**WELWYN HATFIELD COUNCIL – DEVELOPMENT CONTROL**  
**DELEGATED REPORT**

<b>APPLICATION No:</b>	<b>S6/2009/1019/FP</b>
------------------------	------------------------

The proposed development would involve the resurfacing of an area to the front of the main buildings principle elevation. Currently this area is laid to lawn and was previous granted consent to be a grass tennis court within an application to redevelop the site for its existing use. The area of the proposal measures 95m in width by 21m in depth.

drawing
PROPOSED SITE PLAN

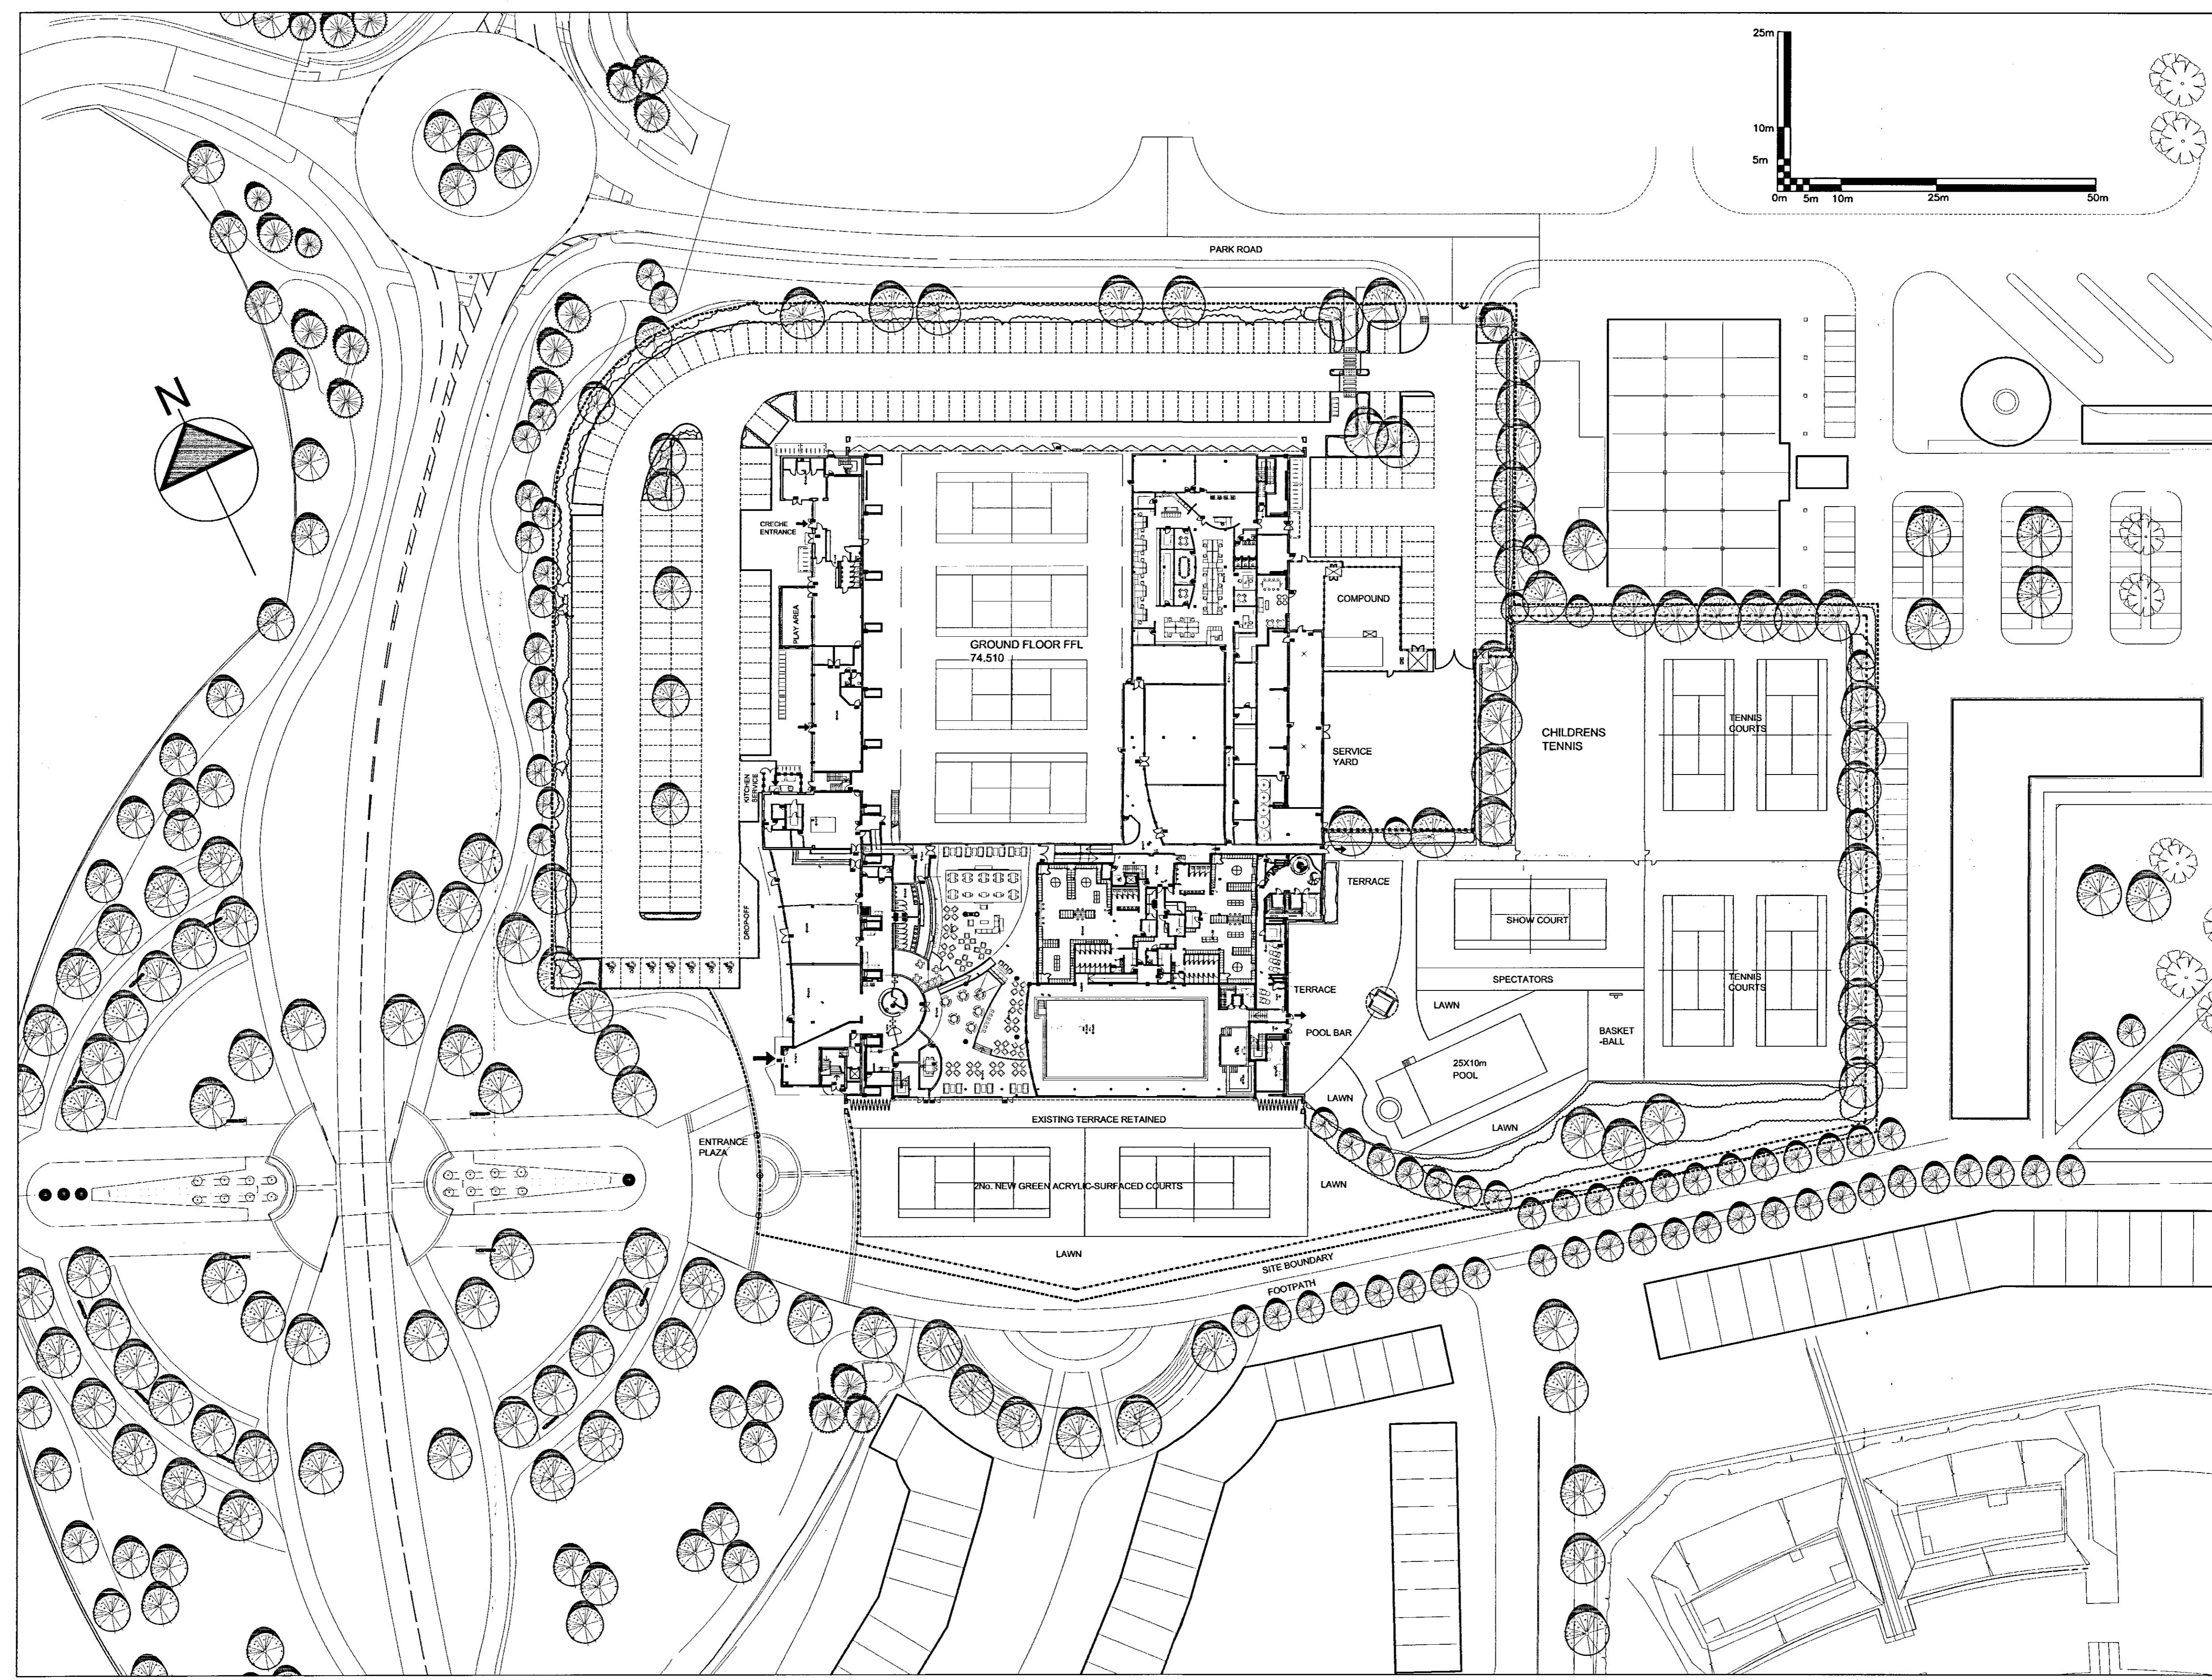
1. The proposed development would involve resurfacing an area to the front of the site to accommodate two tennis courts. As existing the area is laid to lawn and in some parts has not been maintained particularly well. The proposed development would have a green finish and a lawn area would be to the southern and eastern edges of the site.

It has been noted that the existing grass areas have a natural appearance and the proposal would be artificial. However, the proposed development would have a similar appearance to grass and would not appear out of place when viewed from the surrounding public areas. Furthermore, the proposed surfacing could be conditioned to ensure that an appropriate shade of green is used that would harmonise with its surroundings.

The proposed development would not have an adverse impact upon the character and appearance of the locality. Subject to conditions to agree the colour of the proposed surface, the development would not have an adverse impact upon the character, visual amenity of setting of the adjacent Grade II\* Listed Building.

- 1. C.2.1: Standard Time Limit
- 2. C.13.1: Development in accordance with approved plans/detail Site Location Plan 1:1250 & L(0)10 & L(0)11 received and dated 16 June 2009.
- 3. C.5.1:Materials to be agreed
